re: **Landscaping Plan Review - Block 22**
Wateridge Village Residential Development - Phase 1B - Block 22
1400 Hemlock Road - Ottawa

file: PG5345-MEMO.01 Revision 1

Landscaping Plan Review

L-02

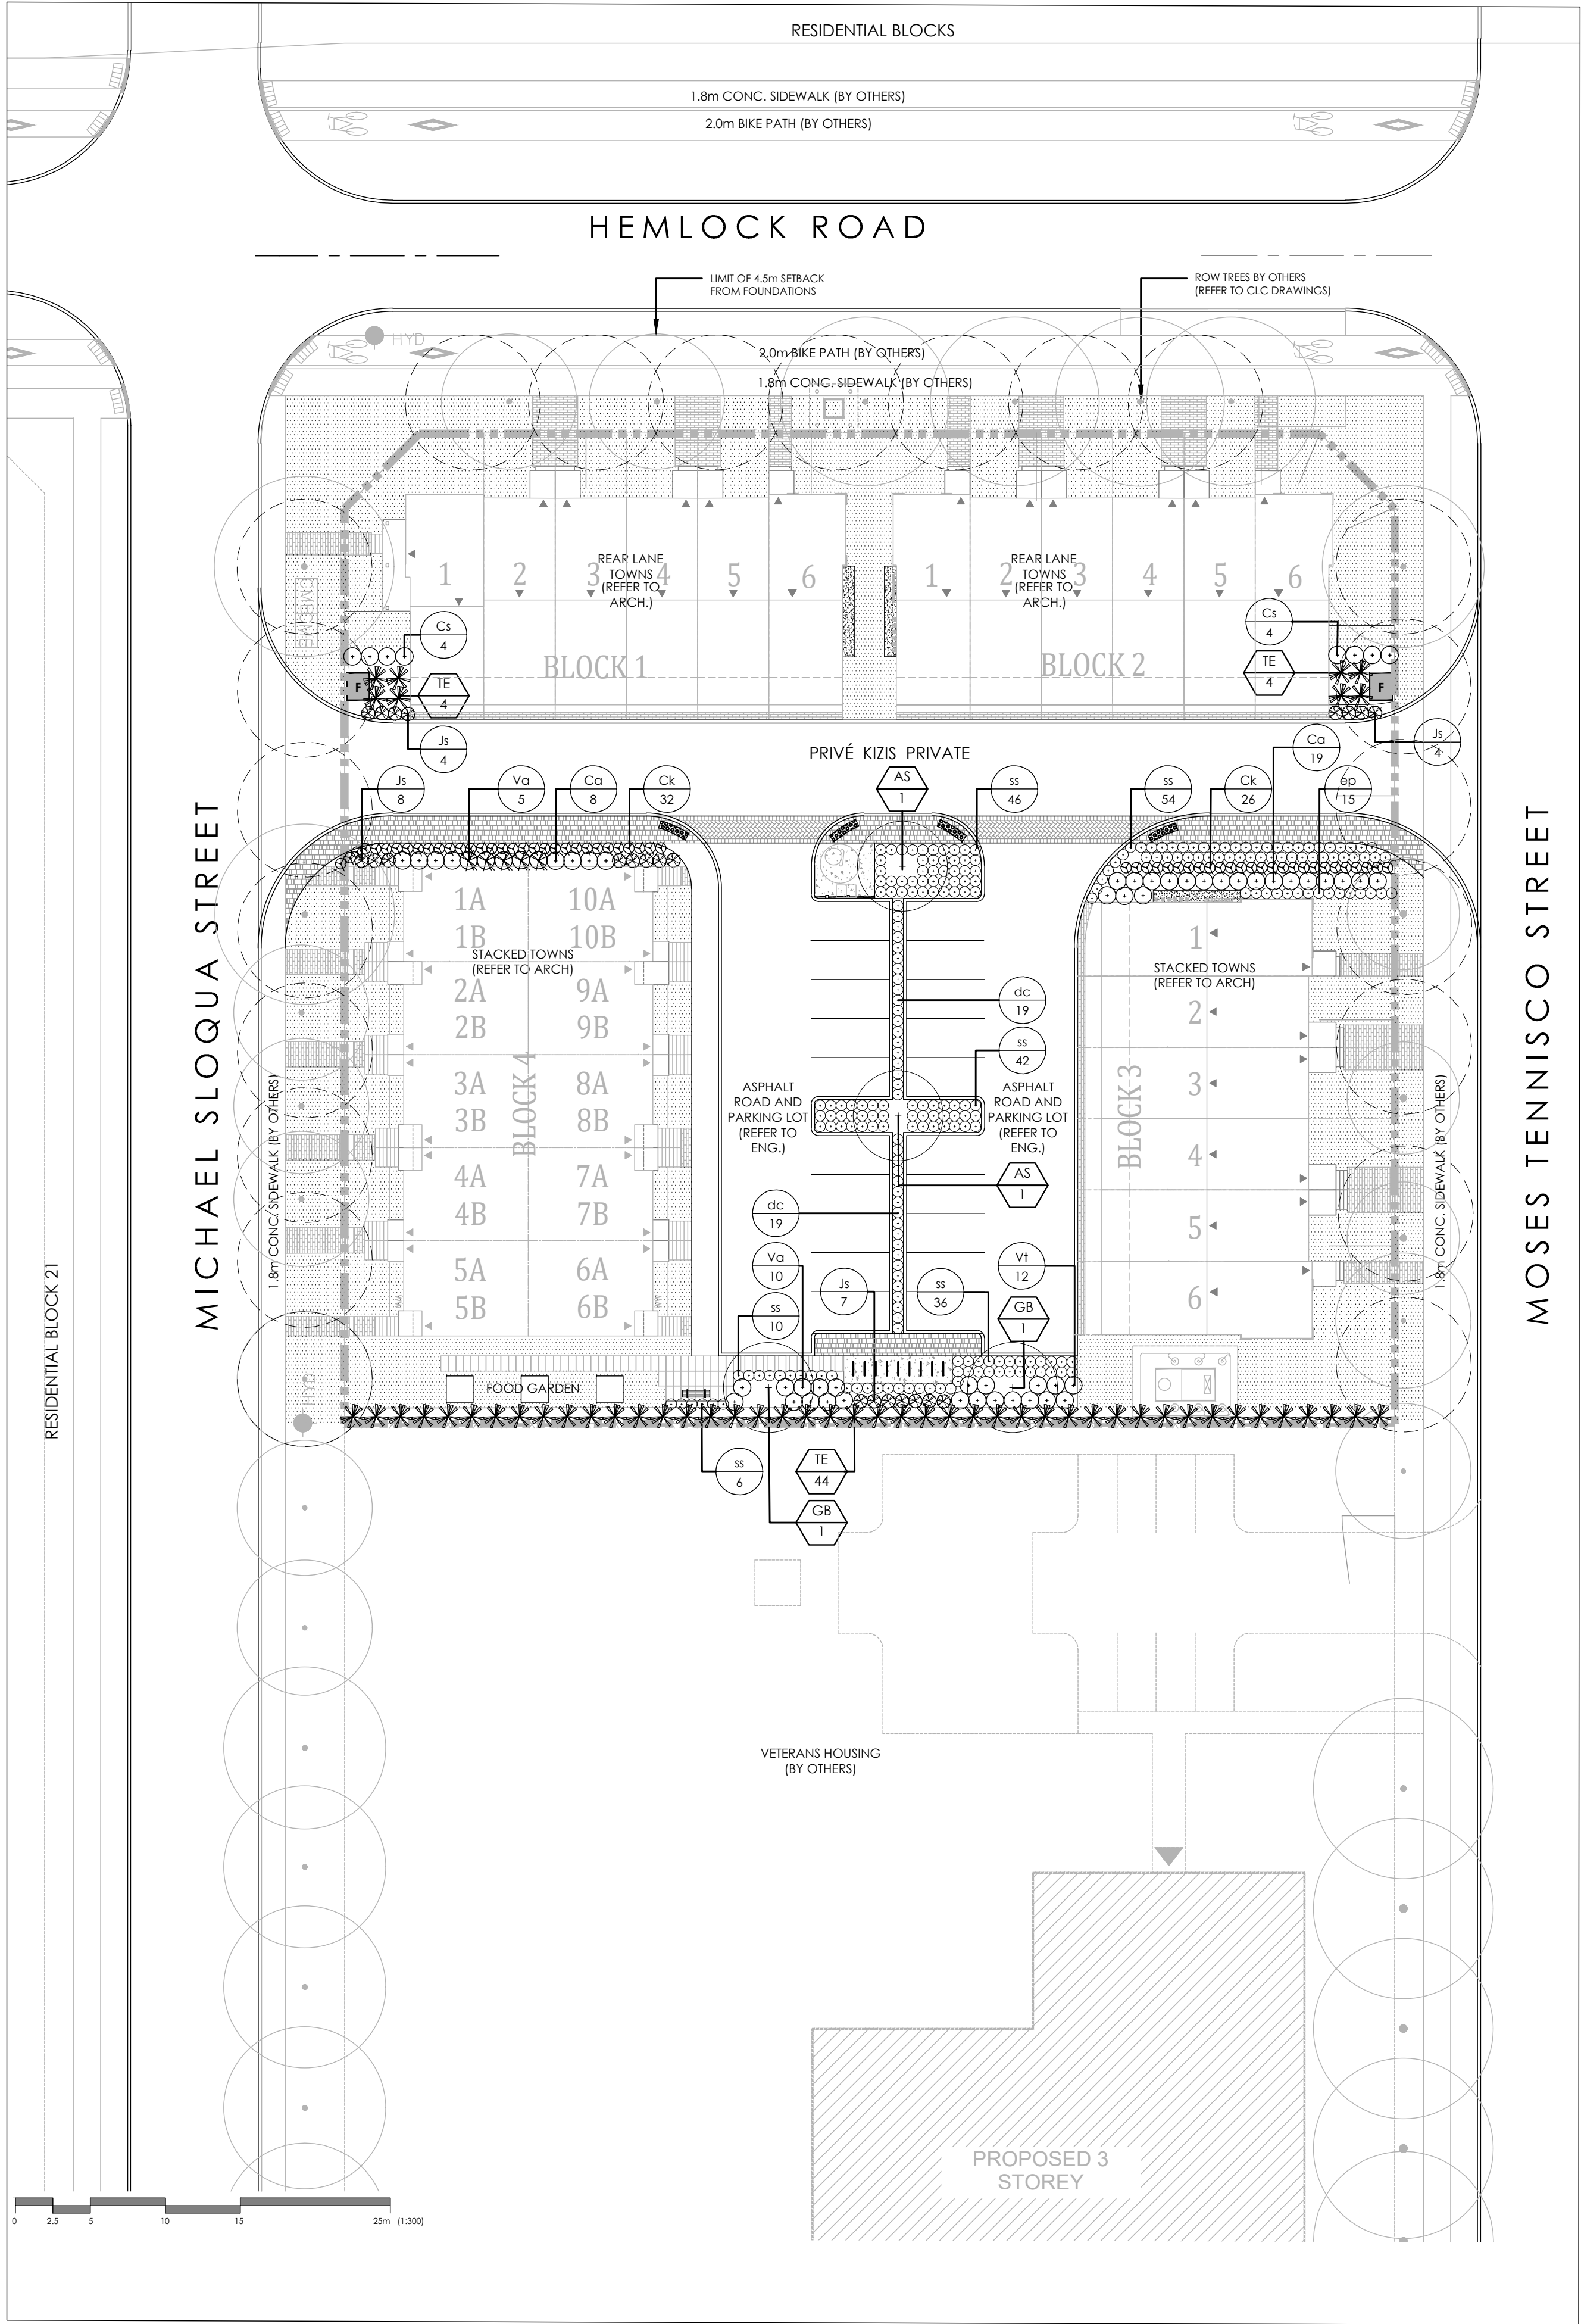
- ❑ Adequate soil volumes are required to be provided for the proposed trees - 25 cubic meters for small trees and 30 cubic meters for medium trees. This should be confirmed by the landscape architect.

- ❑ Tree species are required to be small to medium size, confirmed by the landscape architect. Reference should be made to the section below for comments regarding the tree species and appropriate setbacks from building foundation walls.

The landscaping architect should confirm that the tree species placed within 7.5 m of the foundation wall consist of small and medium size trees with a mature tree height less than or equal to 14 m. It is understood that the tree heights listed on the plan are the mature heights of these trees in natural conditions and not in city conditions.
